Recommendation Report for Planning Permission for Works or Extension to a Dwelling

REF NO: FP/82/22/HH

LOCATION: 31 Lindsey Court
Felpham
PO22 8JQ

PROPOSAL: Single storey rear extension.

Proposed Extension and Alterations
at 31 Lindsey Court, Felpham
for Mr and Mrs S Dunkeyson
Drawing P01 May 2022 Scale 1:100 / 1:500 @ A3
Planning Drawing - Floor Plan, Block Plan & Elevation

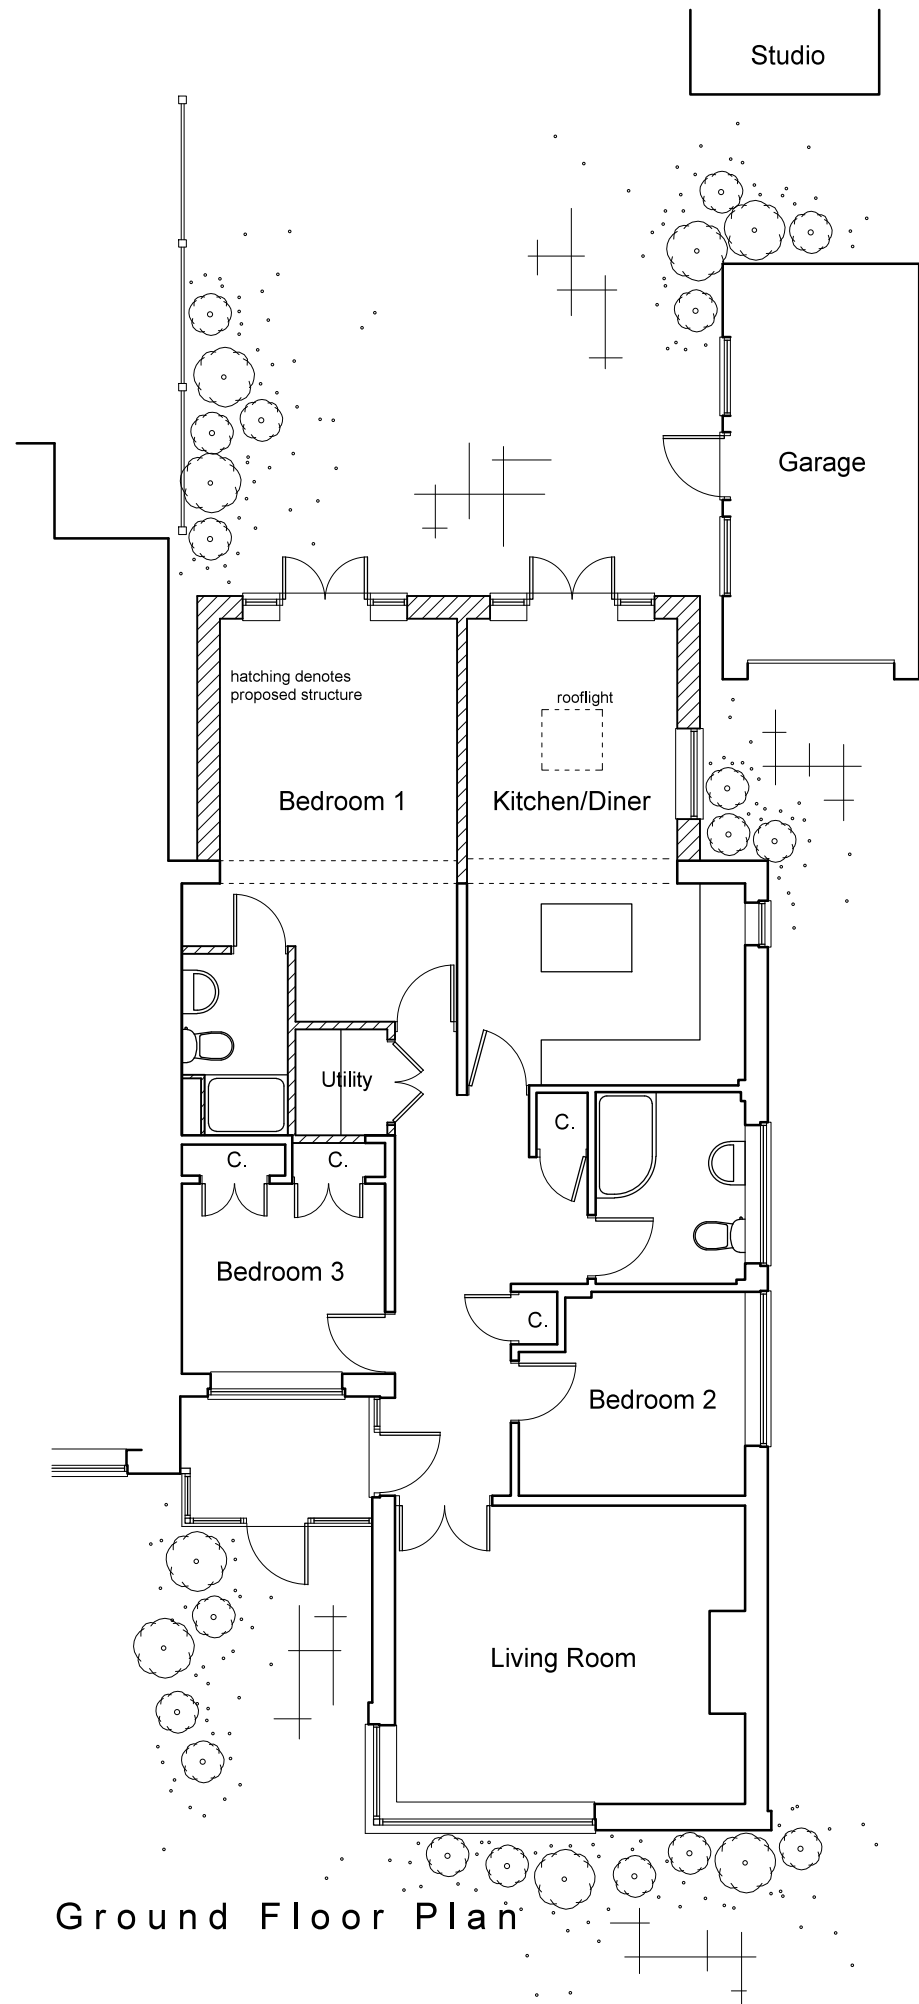
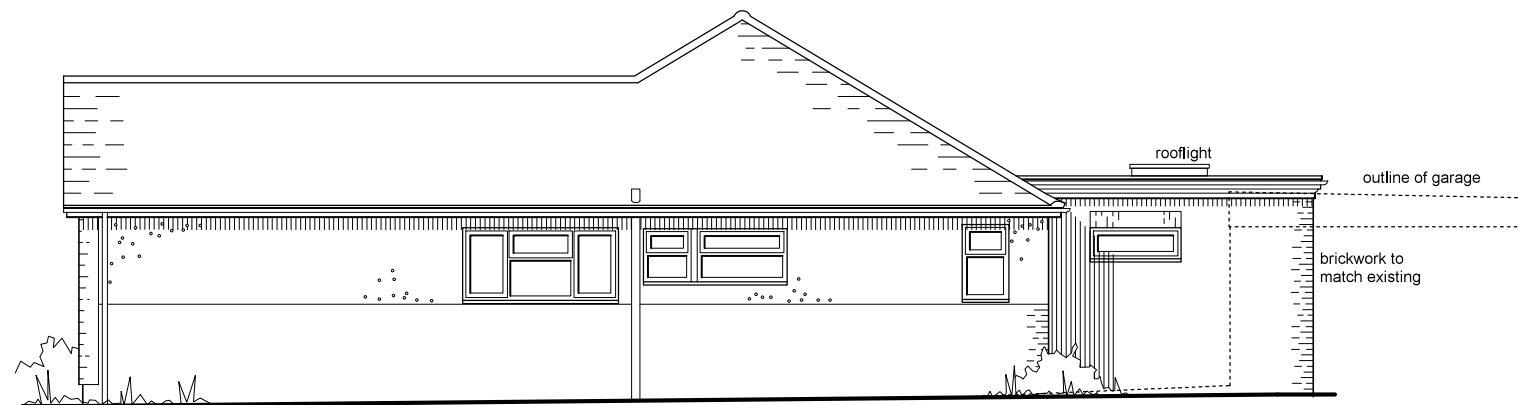
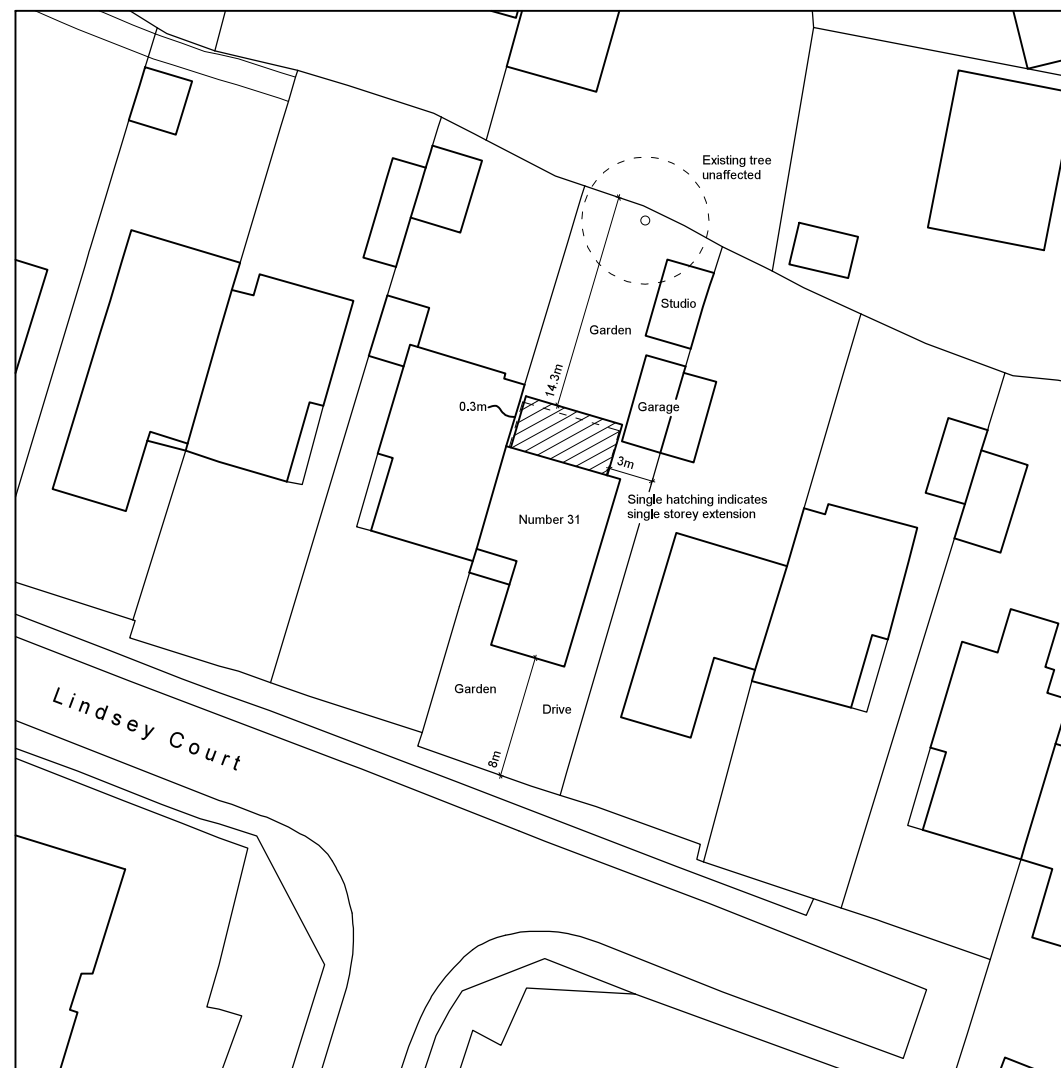
The extension will replace a conservatory to the rear of the property. It will be of similar scale, projecting 3.5m from the rear elevation, but slightly narrower than the existing with a width of 6.67m. It will have a flat roof, differing to the pitched roof of the main dwelling, but following a similar style to the existing garage. Although different to the host, this will not appear unduly out of place and will have minimal harm on the visual appearance of the property. The proposal is in keeping with the character of the property and an appropriate replacement for the existing conservatory. Being to the rear, the proposal will not be visible from the street scene and will have no impact on the composition or appearance of the street. It is in keeping with the character of the area and will have no adverse harm on visual amenity.

The proposal is single storey and will have a flat roof at approximately 2.87m high. This roof will incorporate a rooflight which will protrude marginally above at 3m but will have no impact on residential amenity. The proposal itself will retain 14.3m to the northeast boundary, 3m to the southeast, and 0.3m to the northwest. This is in accord with D DM4 of the Arun Local Plan. Although close to the boundary of No.29, the extension will not project further than the rear elevation of the neighbouring property, resulting in no adverse overbearing or overshadowing of this property. Given its scale and location from neighbouring properties, the proposal will not result in any unacceptable overshadowing or overbearing and will have minimal harm on residential amenity.

In addition to the rooflight, the extension will feature a small window to the southeast elevation, and two sets of French doors with sidelights to the northeast elevation. The features to the northeast will face the rear garden and will not overlook any neighbouring properties. They pose no risk of harm to residential privacy or amenity and are acceptable. The window to the southeast will face towards No.33 but will not overlook the property itself, instead facing the garden. Given its scale, it will have no harm on neighbouring privacy or amenity.
